Your Ref: ABP-319741-24
Our Ref: **SID-KY-2024-016**
(Please quote in all related correspondence)

Re: Notification under the Planning and Development Act, 2000, as amended.

Proposed Strategic Infrastructure Development (SID): Proposed Wind Farm Repowering Application of the existing Kilgarvan Wind Farm in the townlands of Inchincoosh, Inchee, Lettercannon, Coomacullen and Cloonkeen, County Kerry

DRAWING BY: **Joseph O'Brien** ORIGINATED BY: **Oria Murphy**
PROJECT No: **211107** DRAWING No: **211107 - 07**

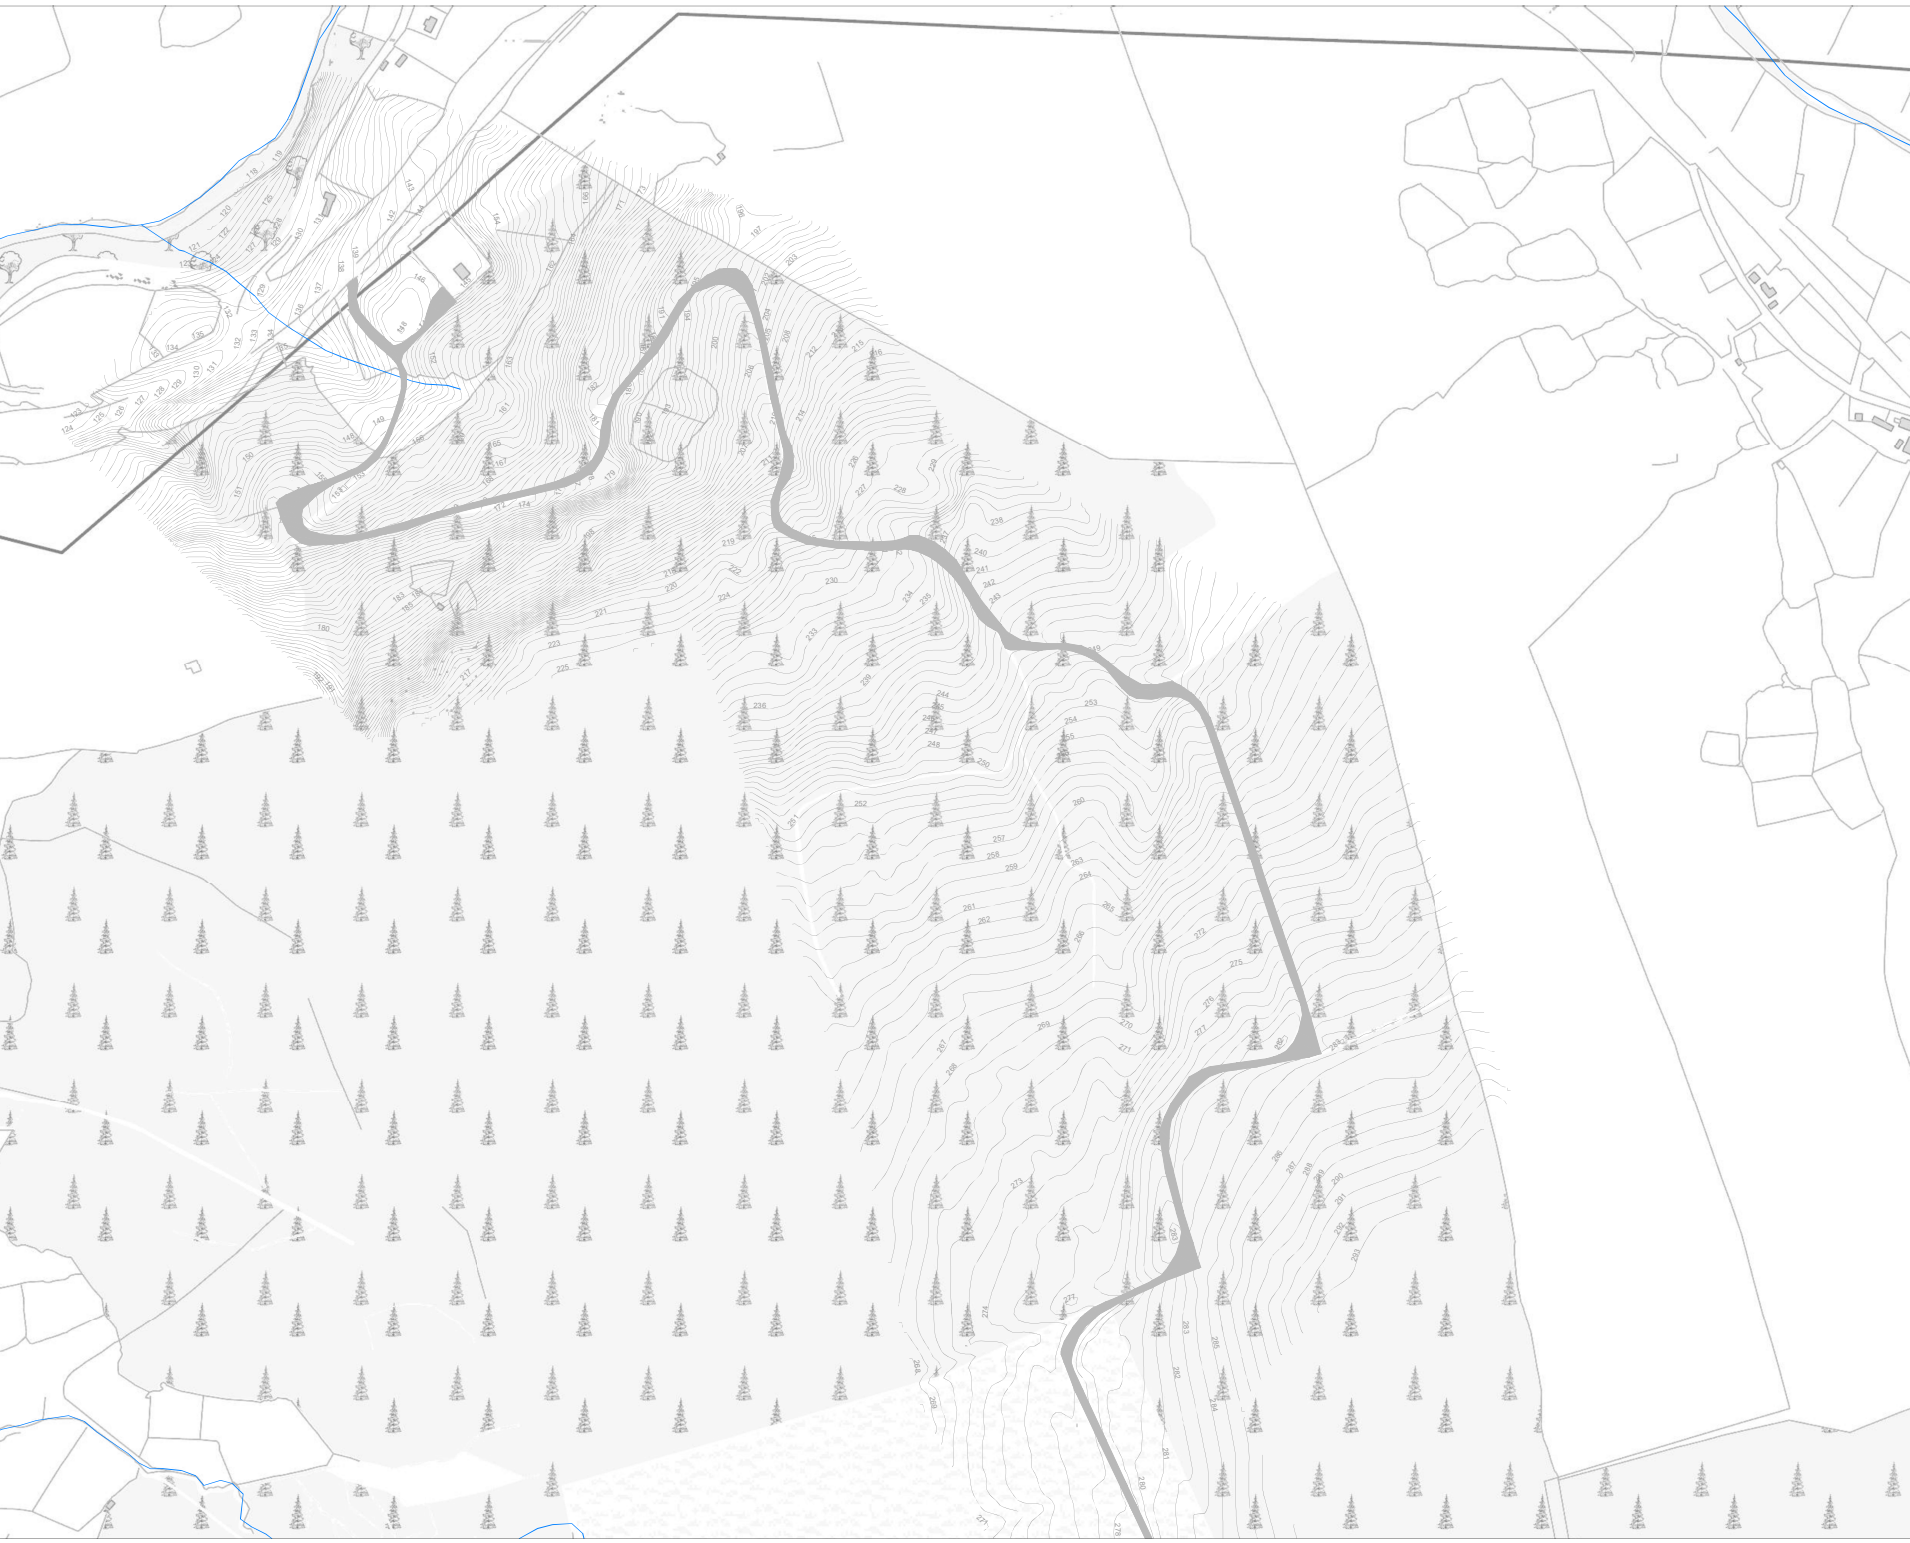
While it is recognised that the existing turbines on the slope edges of the Roughty Wind Farm are being discontinued and replaced by larger turbines further back (Site Layout Plan, Sheet 8), nevertheless, serious concerns remain about collision risk, particularly due to topography (e.g. turbines T10 and T11), in the absence of a topographic risk assessment. Also, the feasibility of more sophisticated mitigation needs to be assessed (e.g. automated curtailment systems⁷). The existing EIAR may not meet the criteria of the Kerry County Development Plan objective 12-9 to demonstrate sufficiently that there will be no significant adverse effects on the natural environment.
